REQUEST

Current Zoning: R-3 LWPA (single family residential, Lake Wylie Protected Area)
Proposed Zoning: MX-2 Innov LWPA (mixed use, innovative, Lake Wylie Protected Area)

SUMMARY OF PETITION

The petition proposes a residential community containing a maximum of 322 residential units. The unit mix could consist of single family detached and/or single family attached dwelling units and /or multi-family attached (triplexes) dwelling units with innovative standards.

RZP-2022-089

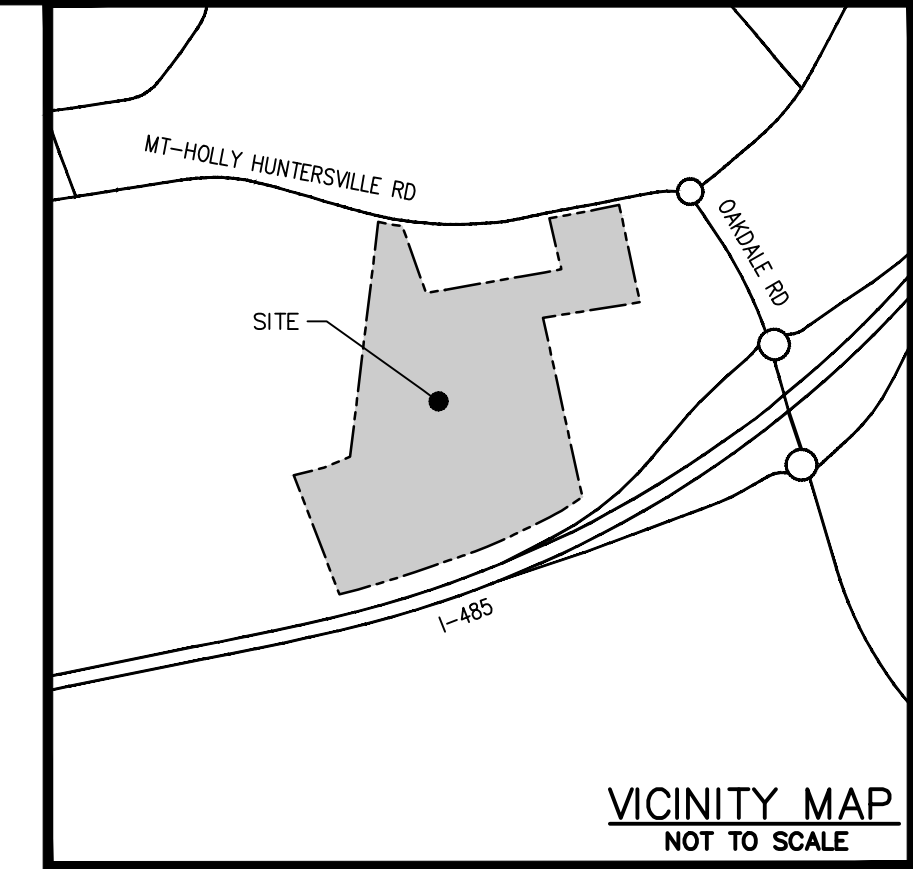
6. ~~Remove garages.~~ Addressed
7. Remove perpendicular parking from public streets. Parking along public roadways shall be parallel parking as shown in previous submissions. Public streets should be constructed to CLDSM standards including design of on-street parking and sidewalk.

8. Site plan and conditional note revisions are needed to show turn lane improvements as outlined above on the site plan. The site plan shall label and dimension the components of the turn lane. Add a conditional note committing to the turn lane improvements. Coordinate with NCDOT on turn lane storage length requirements.

9. Label and dimension the curb and gutter from the centerline for each road on the site plan
